From: Laura Gibbons <Laura.Gibbons@arun.gov.uk>
Sent: 10 November 2020 15:07
To: Planning.Responses <Planning.Responses@arun.gov.uk>
Cc: Michael Eastham <Michael.Eastham@arun.gov.uk>
Subject: A/158/20/DOC- Land South of Water Lane

The information supplied for this DOC is insufficient. We are still agreeing broader principles for the reserved matters application.

RESERVED MATTERS DRAINAGE LAYOUT SHEET 2

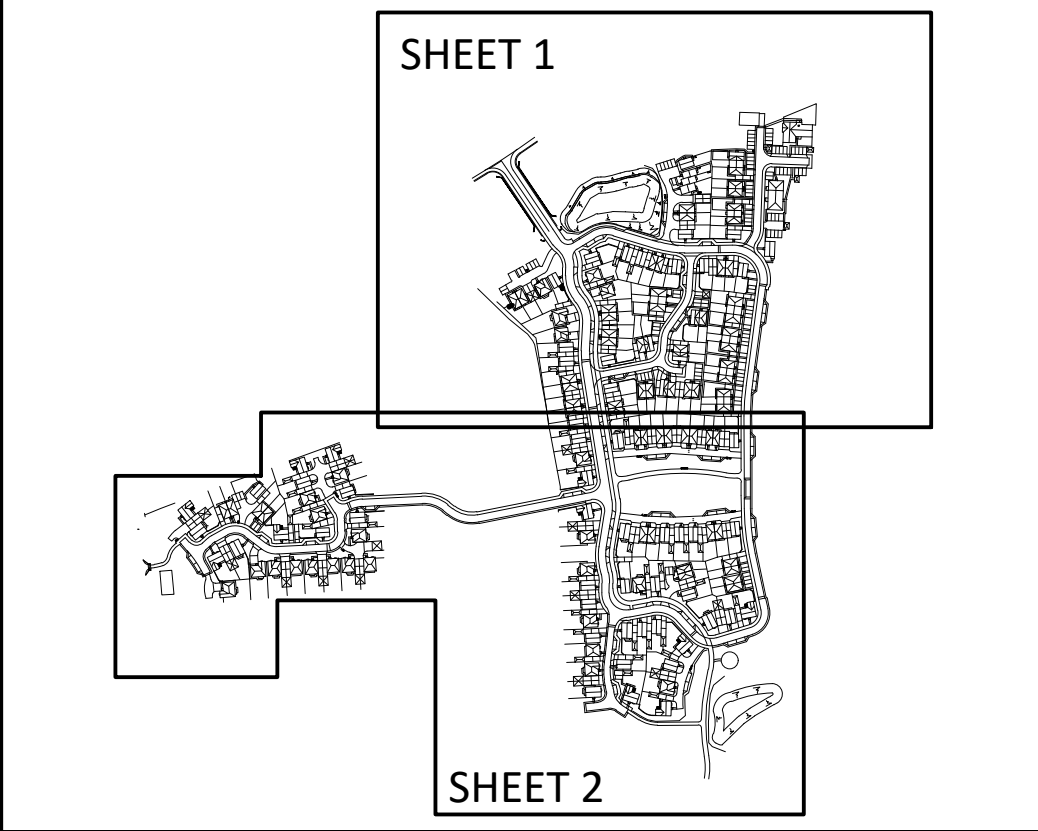
Full detailed layout drawings will be required, showing connections from individual plots to the drainage network. Construction detail drawings will also be required. The applicant should refer to our checklist for full details of the information we require.
